SPR EA1N and EA2 PROJECTS

DEADLINE 6 - RESPONSES TO APPLICANTS D5 COMMENTS ON SASES D4 SUBMISSIONS

Interested Party: SASES **PINS Refs:** 20024106 & 20024110

Date: 3 February 2021

TITLE
ACCESS 13
B1121 SAXMUNDHAM ROAD
CONSTRUCTION PHASE

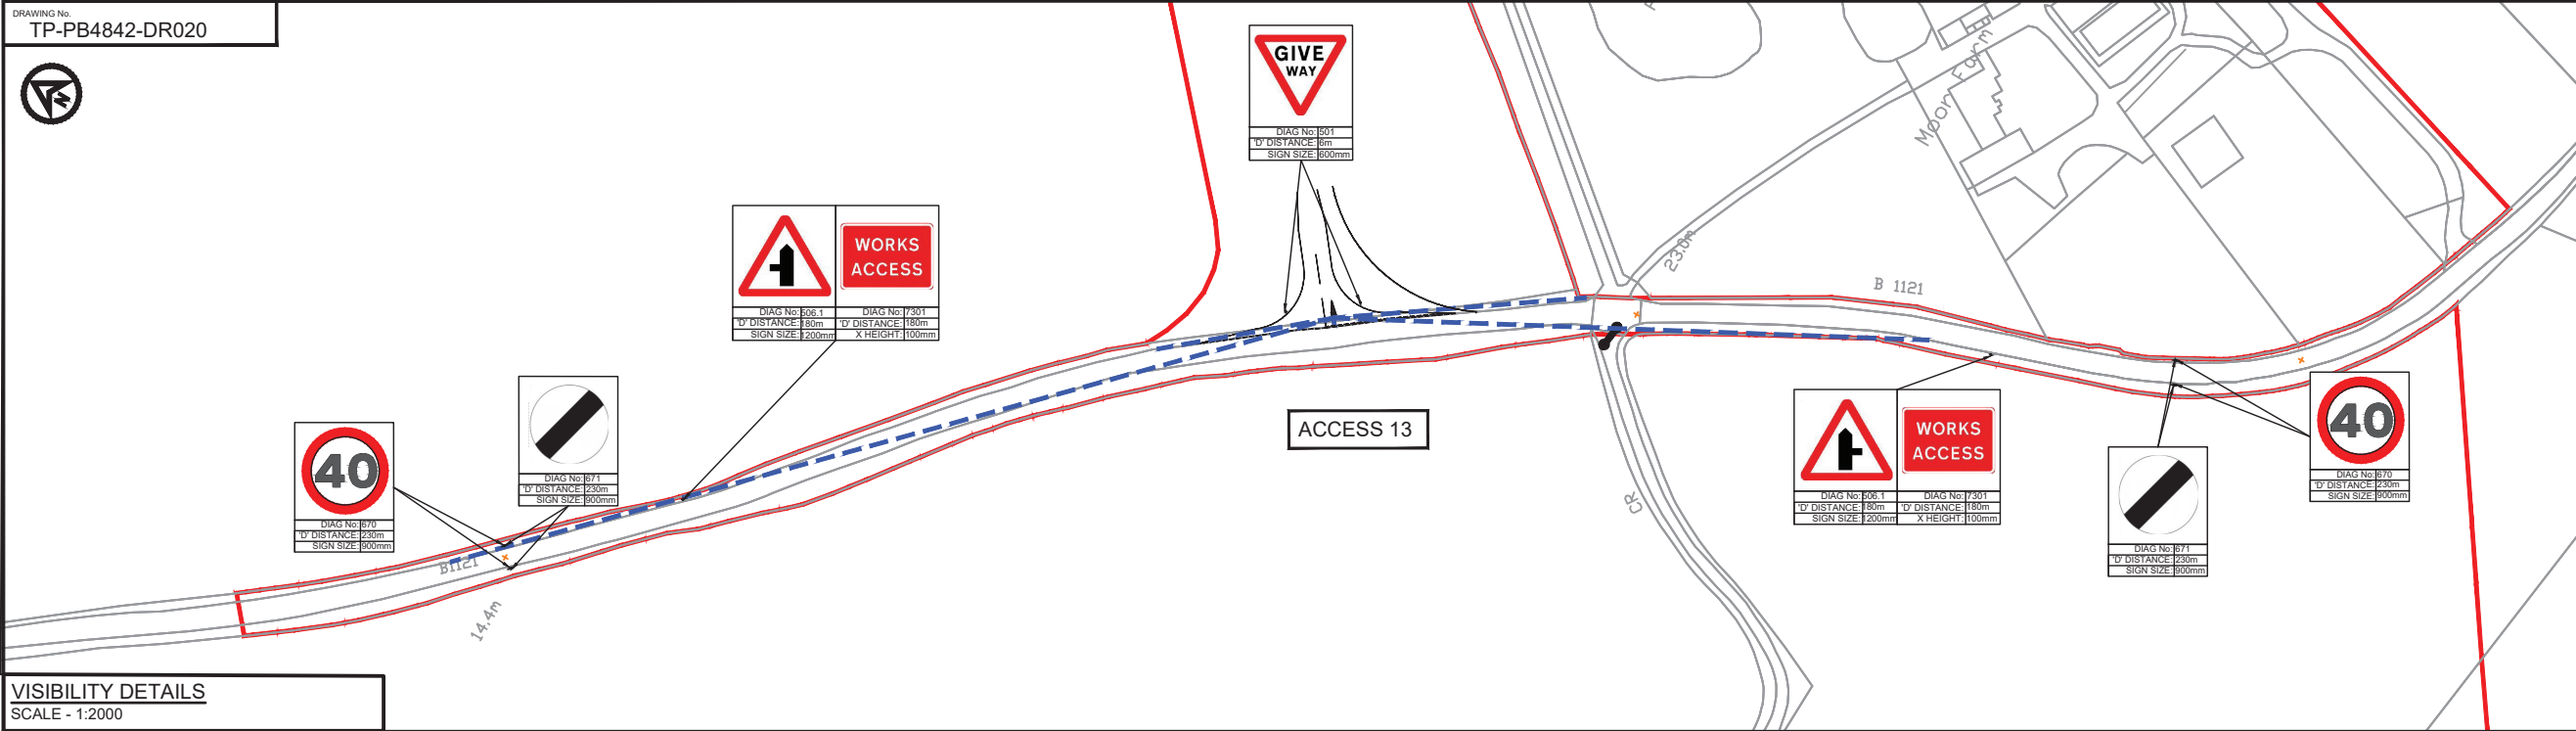
ID	Topic/Document	SASES Comments
2.2 Traffic and Transport		
Outline Construction Traffic Management Plan (OCTMP)		
6		SASES notes that the Applicant envisages the use of Access 13 by large vehicles after construction of the NG substation. This is inconsistent with its use for maintenance purposes and the limitations of the local road network
17,18 &19		The Applicant's response still fails to provide an indication of the likely magnitude or duration of Off-site Highway Works in the local road network
21		It is noted that the Applicant does not refute SASES assertion that impact of 400 HGV movements (pk) plus non HGV site traffic is far from insignificant to the local population.
Outline Travel Plan

TITLE
ACCESS 13
B1121 SAXMUNDHAM ROAD
OPERATIONAL PHASE

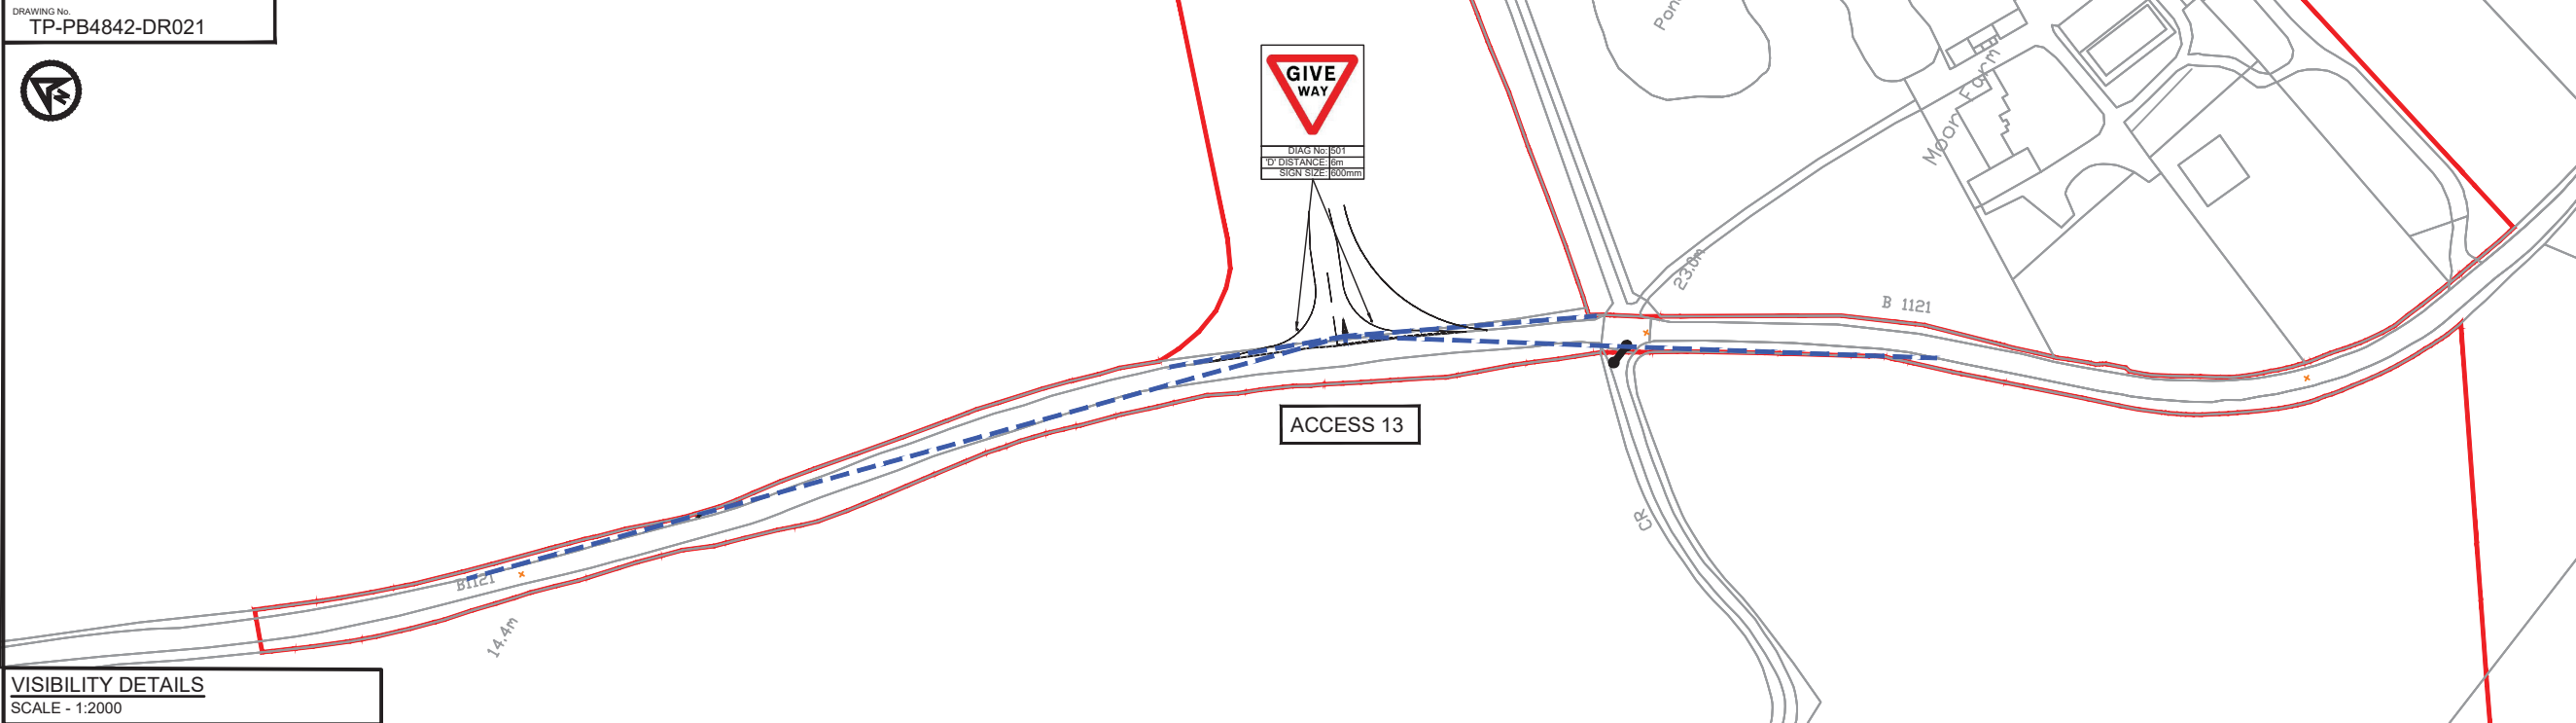
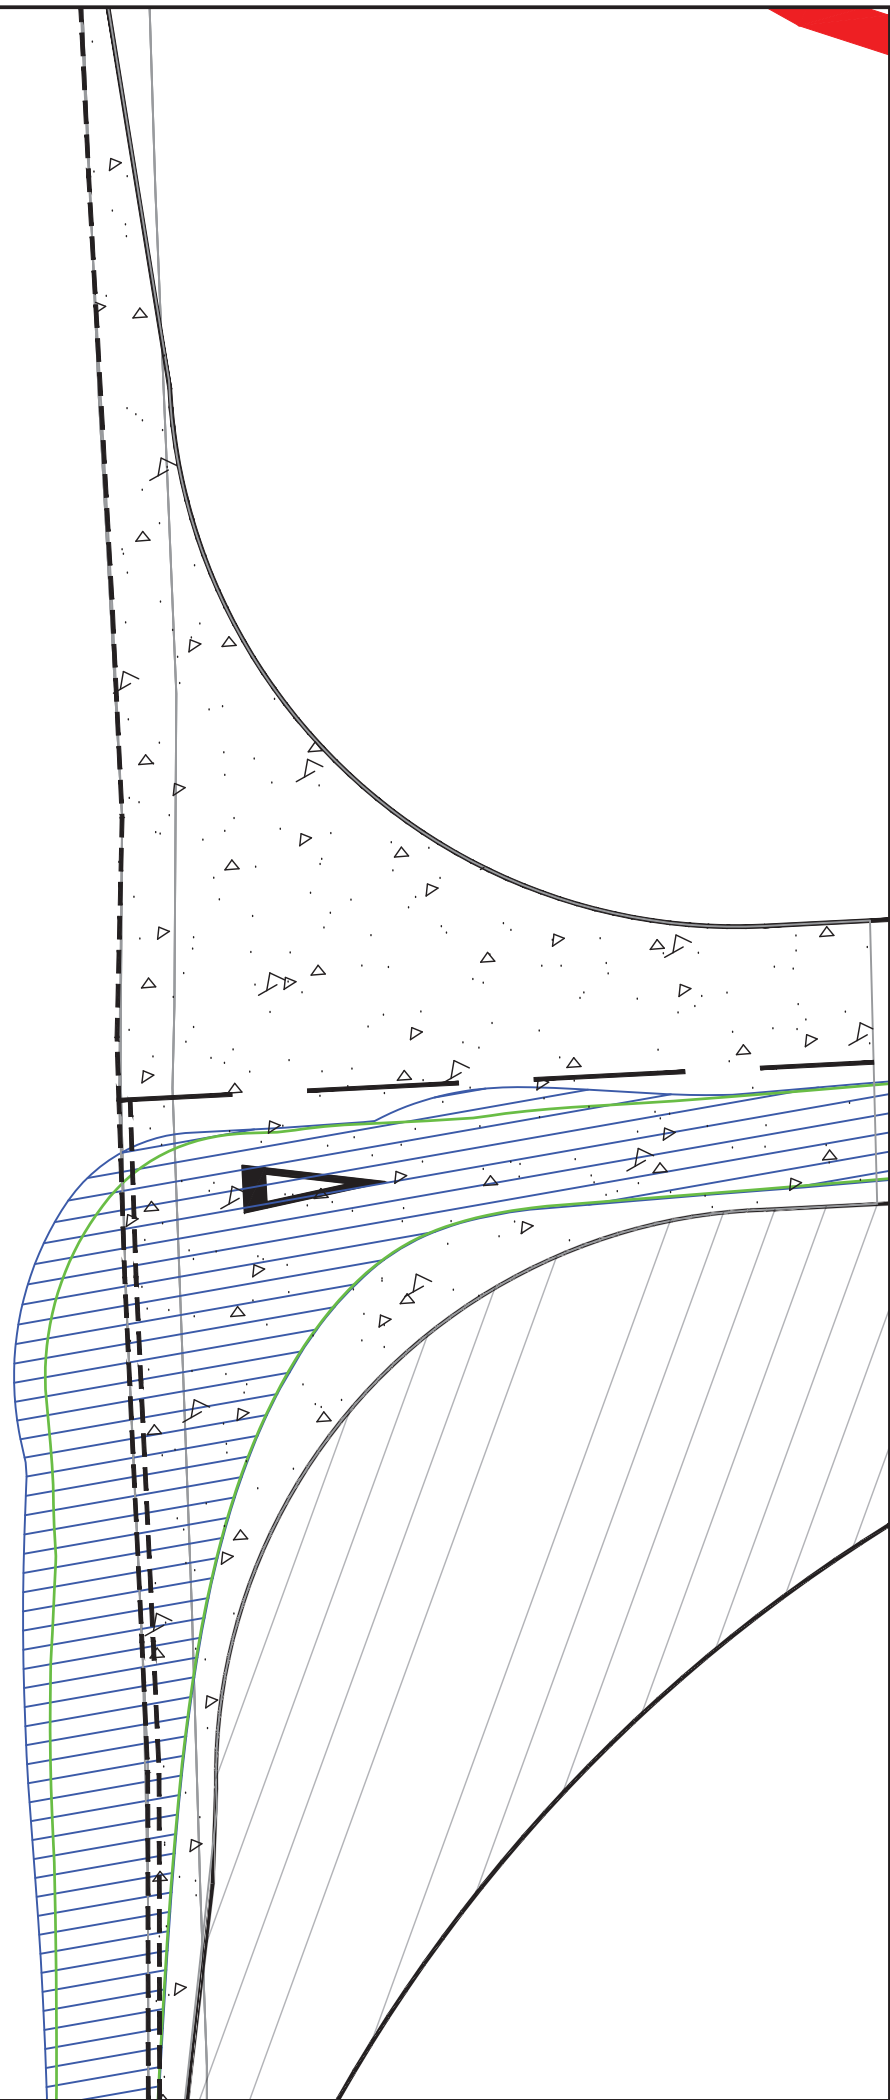
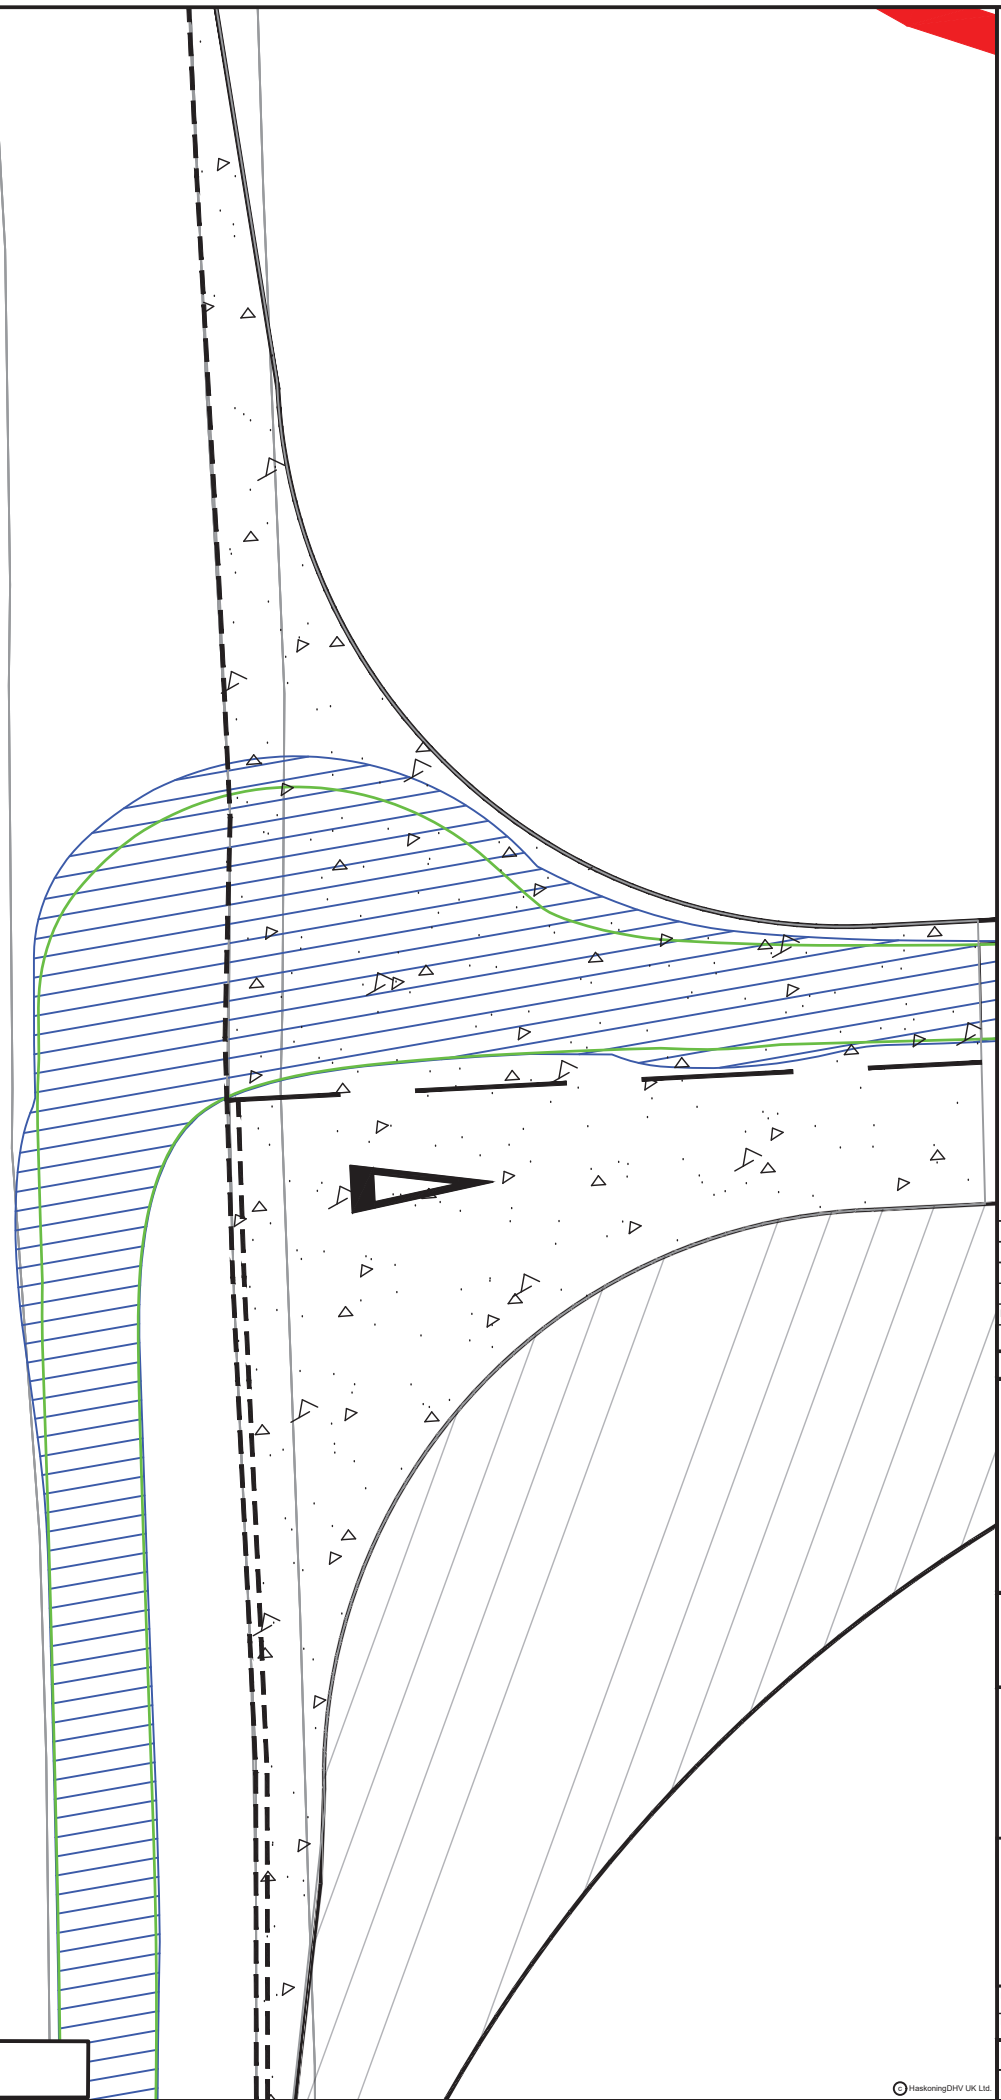
Access Management Plan		
39 &40		It is noted that the Applicant confirms that access to the onshore substation (substations) will be via Access 13 and that vehicle movements would be limited to occasional repair, maintenance, and inspection. The Applicant fails to provide an estimate of the likely number of movements per month (say). This is also inconsistent with ID 6.
41		The Applicant again fails to provide an explicit statement on whether the crossing (11/12) will be manned. It is therefore presumed that the crossing will not be manned. Local knowledge suggests this is an unwise situation given the likely daily HGV movements during initial stages of substation construction. Absence of this point from a Project Risk Register would reflect badly on the Applicant
57,58 & 59		It is suggested that the Applicant revisits these proposed works to ensure there is no risk to passing motorists or pedestrians as a consequence of the very limited clearance between working machinery and vulnerable passers-by.
